East Anglia ONE North and East Anglia TWO Offshore Windfarms

Applicants' Comments on SASES' Deadline 7 Submissions

Applicant: East Anglia TWO and East Anglia ONE North Limited
Document Reference: ExA.AS-22.D8.V1
SPR Reference: EA1N_EA2-DWF-ENV-REP-IBR-001017

Date: 25th March 2021
Revision: Version 01
Author: Royal HaskoningDHV

| Important Hedgerows and Tree Preservation Order Plan Sheet Number: Sheet 2 of 12 | | | Rev | 5 | British National Grid OSGB36 |

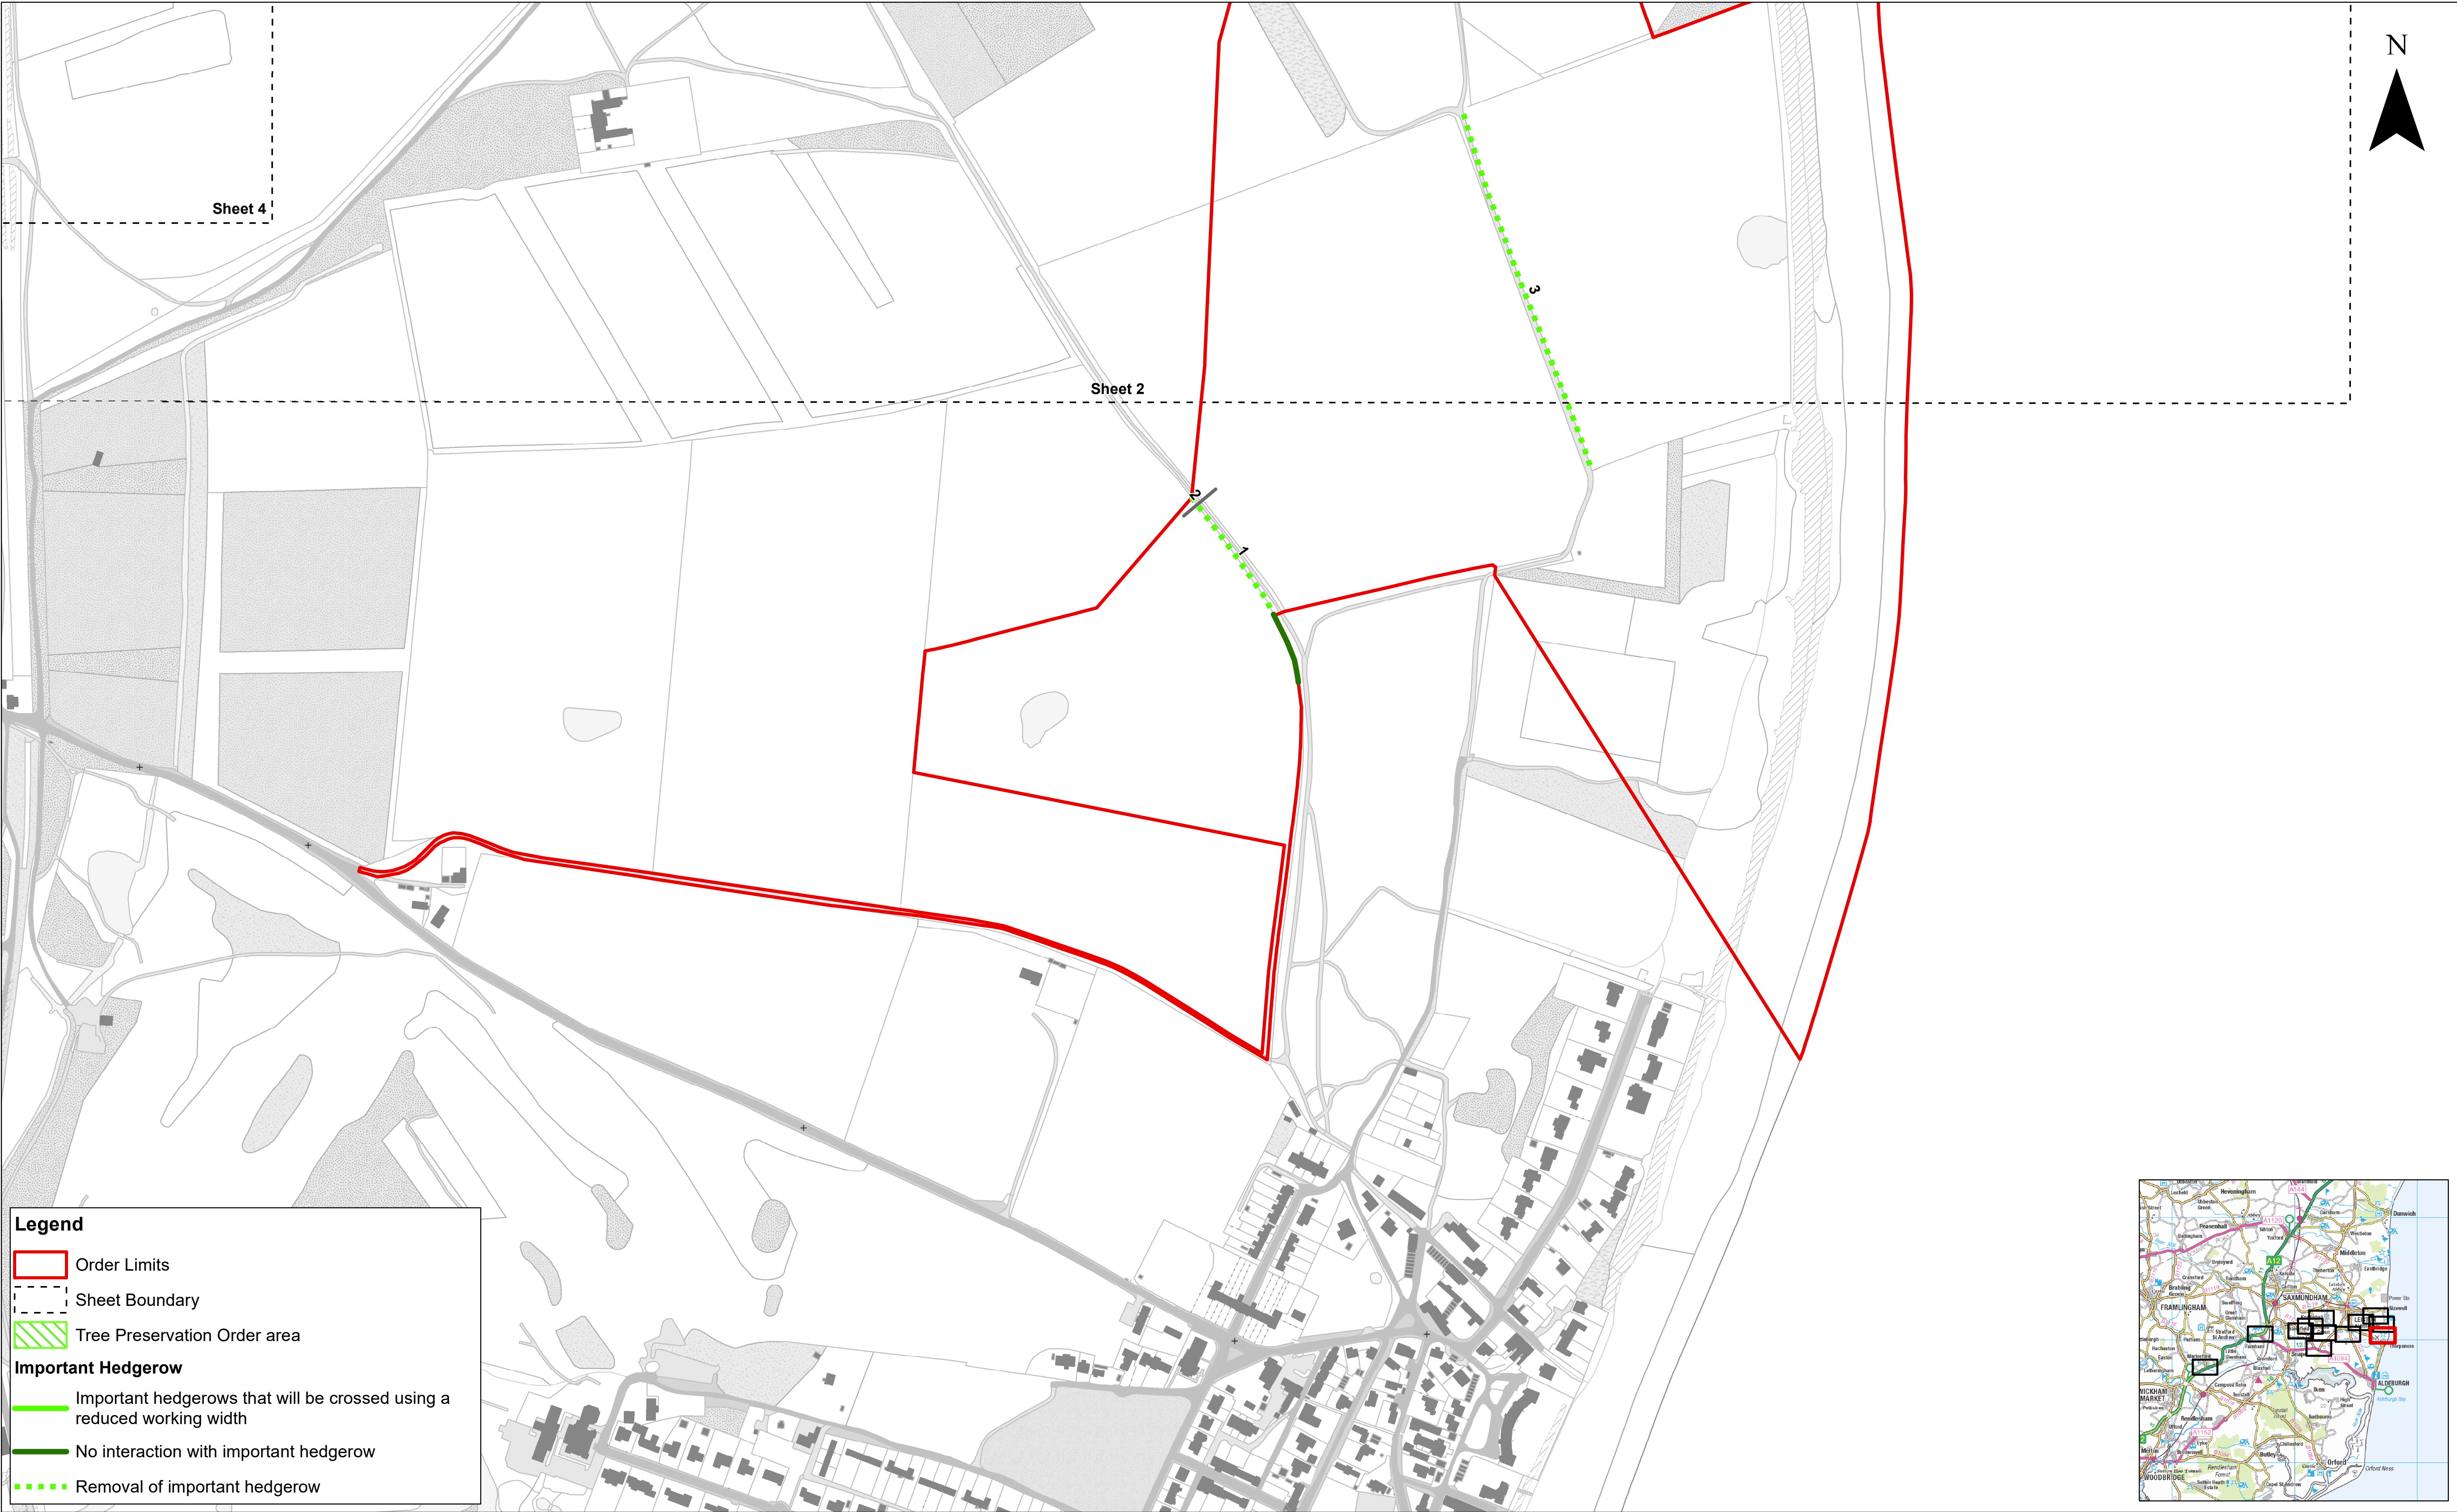
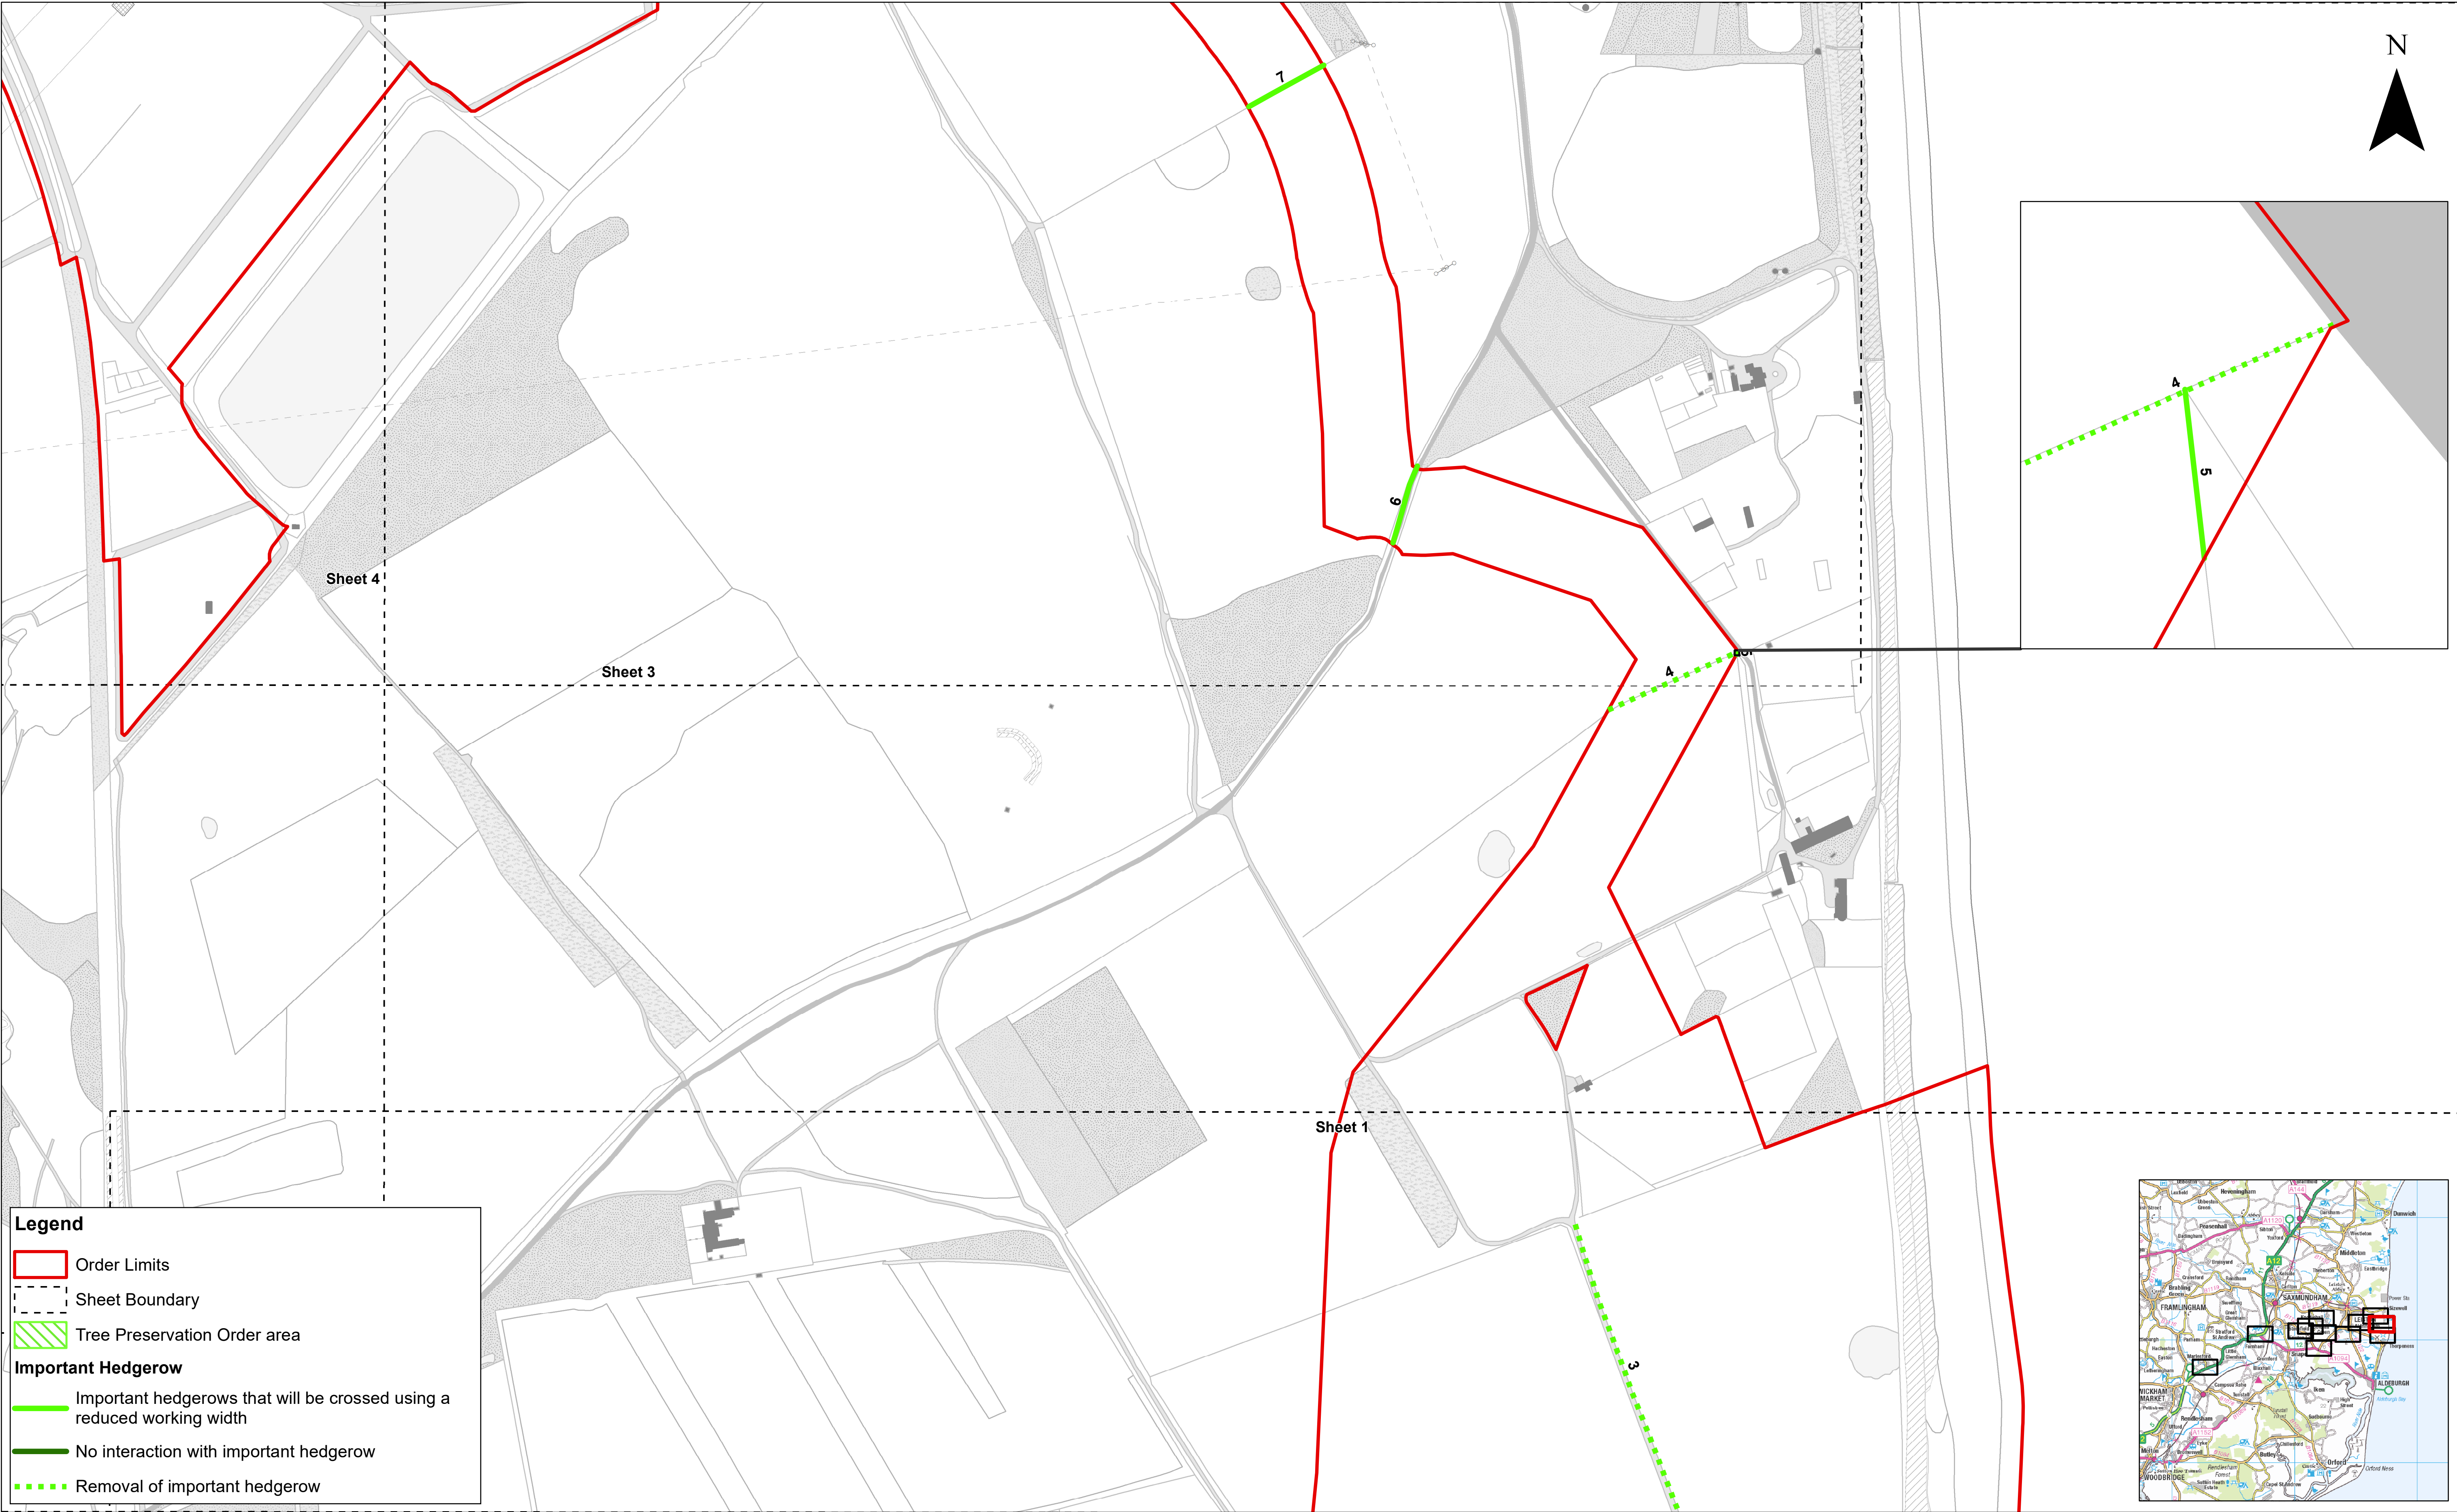
ID	SASES' Comment	Applicants' Comments
	 <p data-bbox="344 1034 846 1066"><i>Hedgerow 5 (running west from wooded pit)</i></p>
